# INDEPENDENT AIR QUALITY REVIEW WESTCONNEX – M4-M5 LINK

NSW Department of Planning & Environment

28 February 2018

# Independent Air Quality Review WestConnex – M4-M5 Link

LEGEND

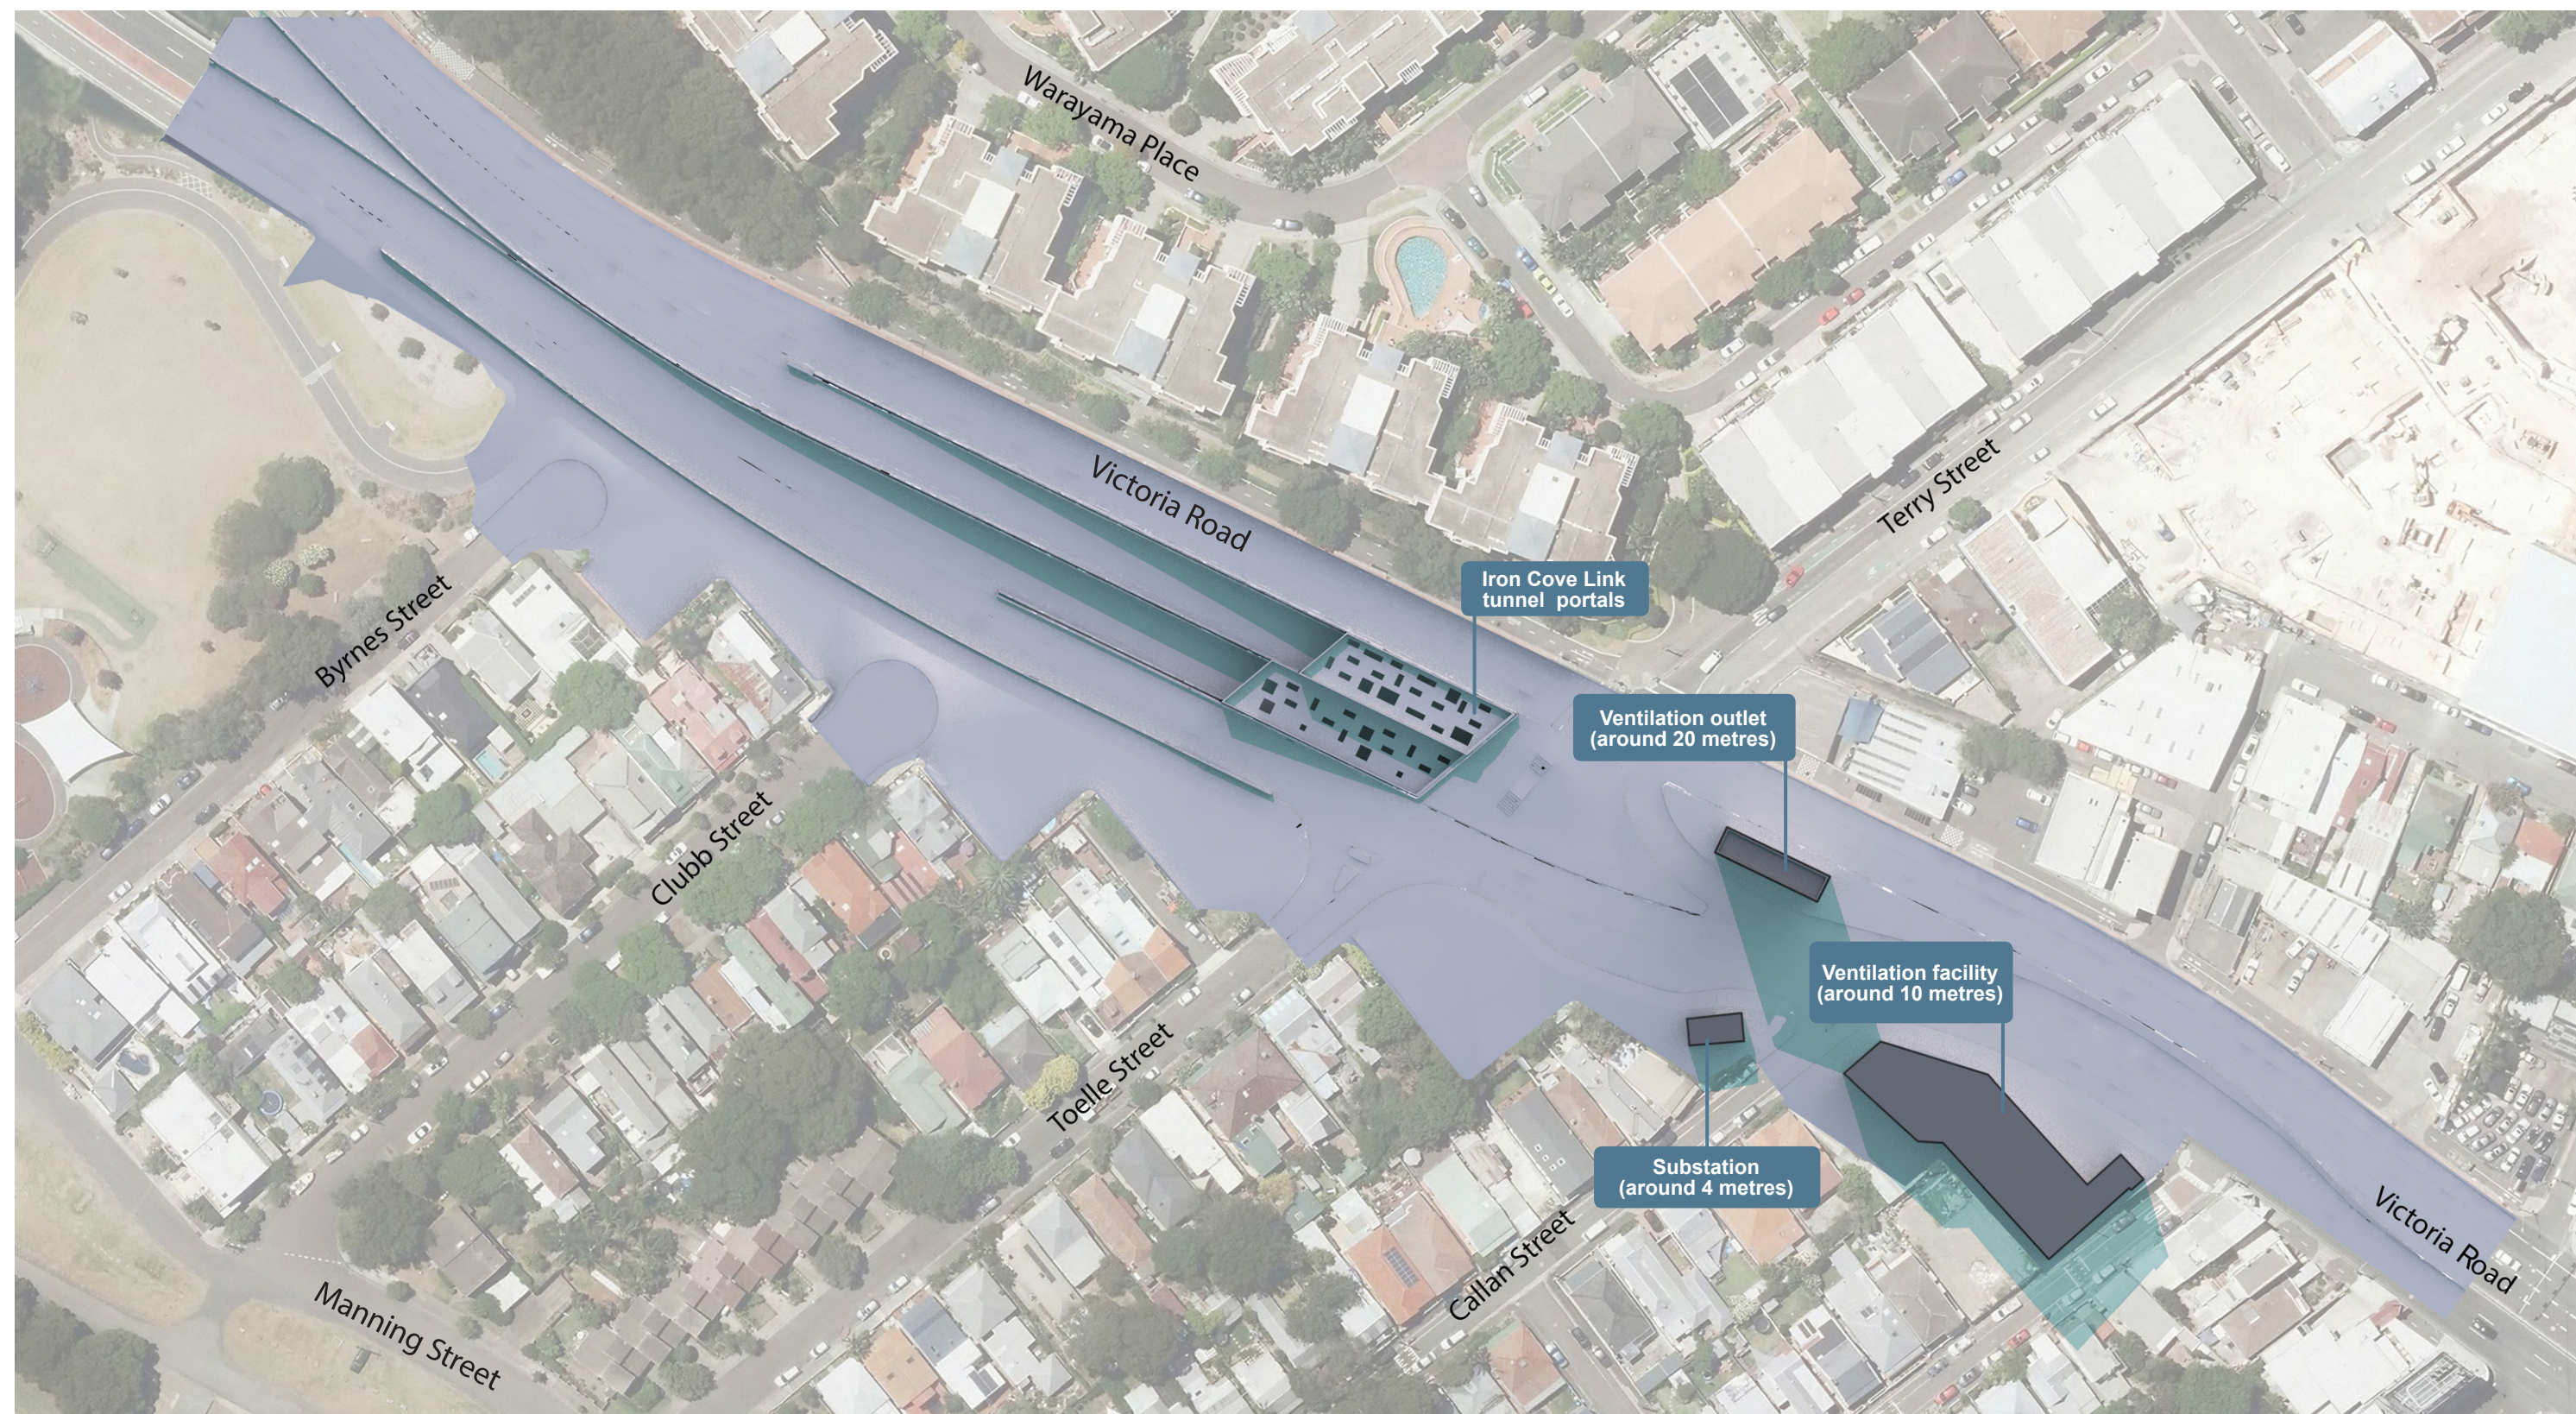
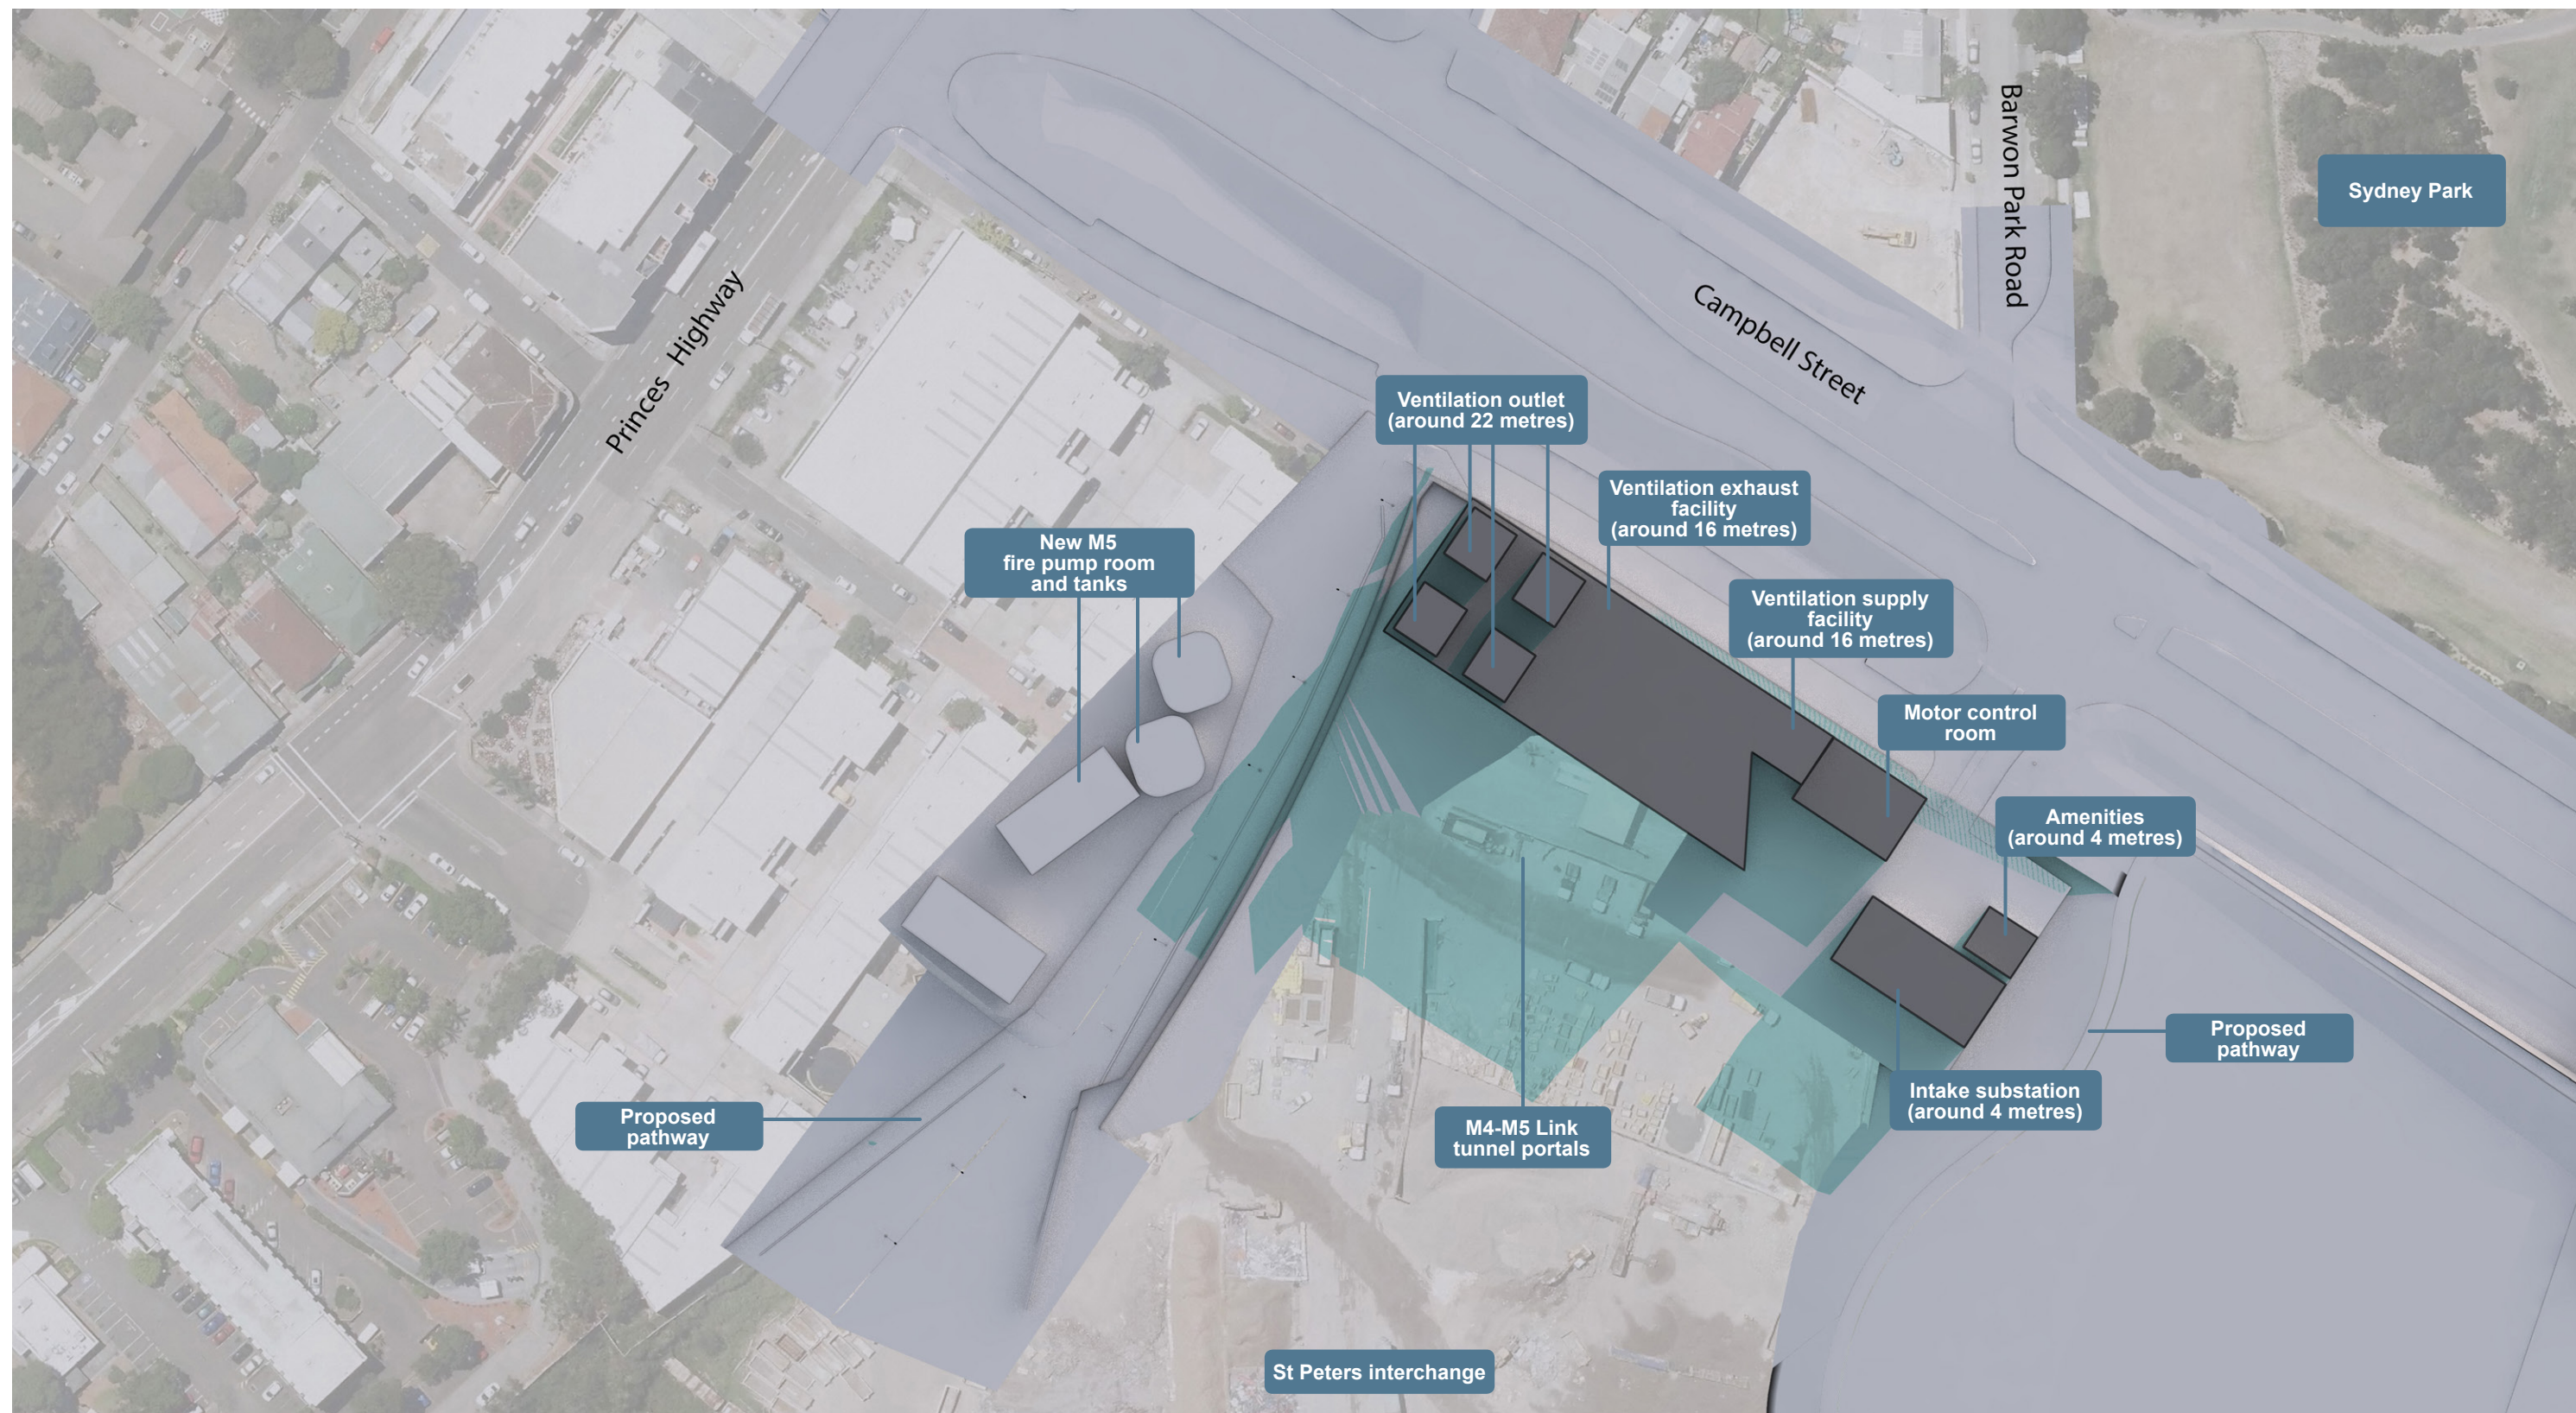
The air quality assessment comments *“there are only a small number of tall buildings in proximity to the proposed ventilation outlets, and therefore the effects of building downwash (refer to Annexure B) would probably have been rather limited”*.

The sensitivity test indicated that concentrations associated with the ventilation outlet on average increased by a factor of approximately 1.3. As the predicted impacts are low, it was determined that buildings effects are unlikely to represent a large source of uncertainty in the overall predictions.

Modelled concentrations for the Project effects on surface roads were predicted at two elevated receptor heights (10 metres (m) and 30m) for annual and 24-hour average PM<sub>2.5</sub>. The results indicate the influence of surface roads reduced at 10m and was negligible at 30m, and that near the ventilation outlets pollutant levels from the outlets were greater at 30m height than at 10m.
